Application no: 21/01758/DISC

Location: Dorchester Phase 5D, Phase 8C and Trenchard Circle, Heyford Park
Camp Road Heyford Park Bicester OX25 5HD

Transport Development Control

This application is seeking the discharge of condition 14(Travel Pack) for the development at above site

**Heyford Park Site Layout**

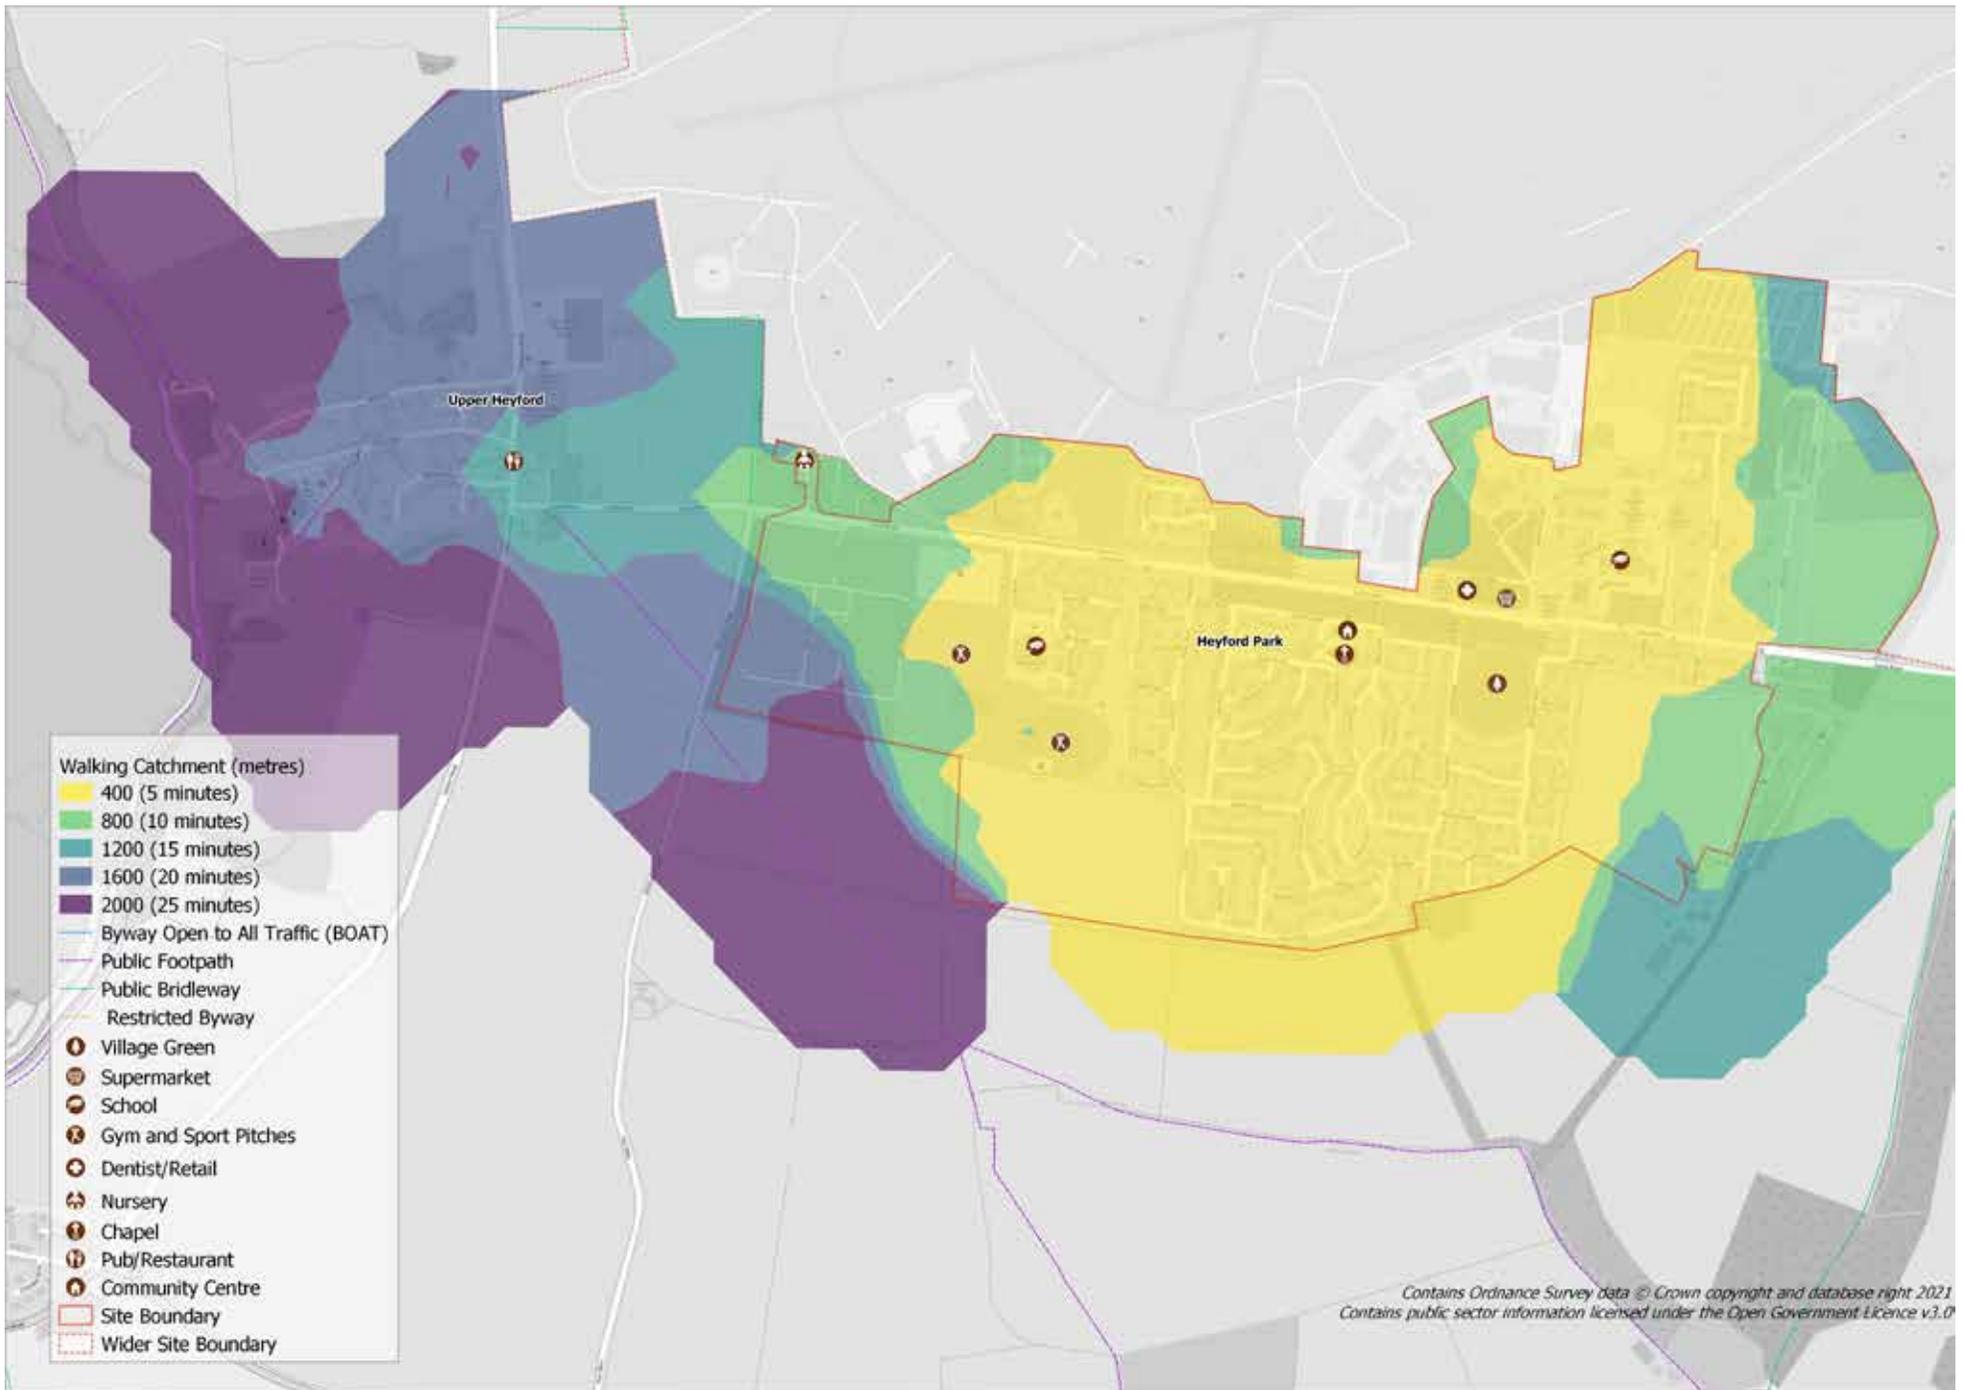
- Add the location of the site onto the site layout map. Make this clear.
- Section 2 – provide email addresses for the useful contacts.
- Section 3 – provide details on cycle parking.
- Section 5:
 - Detail key destinations and journey times.
 - Add a link to the [Railcards website](#).
- Add a section on EV charging.
 - Include [Park & Charge Oxfordshire](#).
- Add a section for local taxi companies.
- Add a section detailing supermarket delivery options.
